Matter 1: Resilience, Continuity, and Security

Matter 2: Historic Environment (ES Appendix 11.2)

Image 4.4 Illustrative example of extension to Bramford Substation (extension shown in grey)

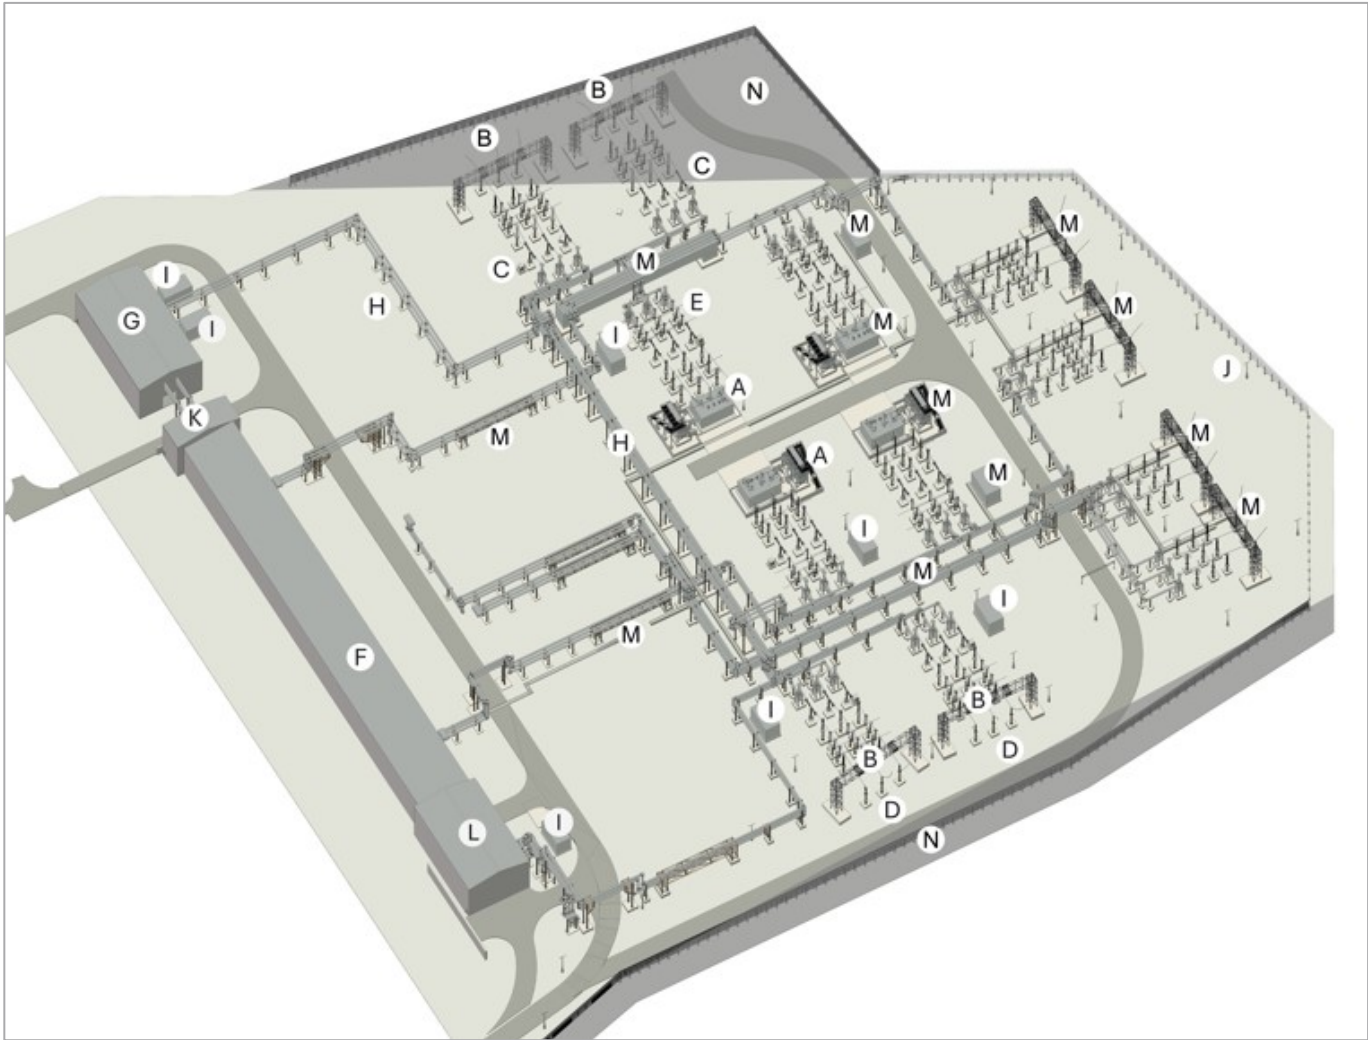
4. Mitigation and Design Dispersal. A sound design should incorporate risk dispersal. The current concentration of infrastructure, particularly when sited adjacent to flammable and toxic hazards (such as Battery Energy Storage Systems - BESS), represents a failure to apply the 'Safety by Design' principle.

6. Improper Scoping of Cumulative Impacts (Bruntford BESS). The exclusion of the Bruntford BESS from the cumulative impact assessment is a significant procedural flaw. Given that Alcemi has completed pre-planning and is in active correspondence with National Grid, this project is "reasonably foreseeable". Excluding what would be Europe's largest BESS, situated immediately adjacent to the Bramford Substation, renders the current risk and environmental assessment incomplete.
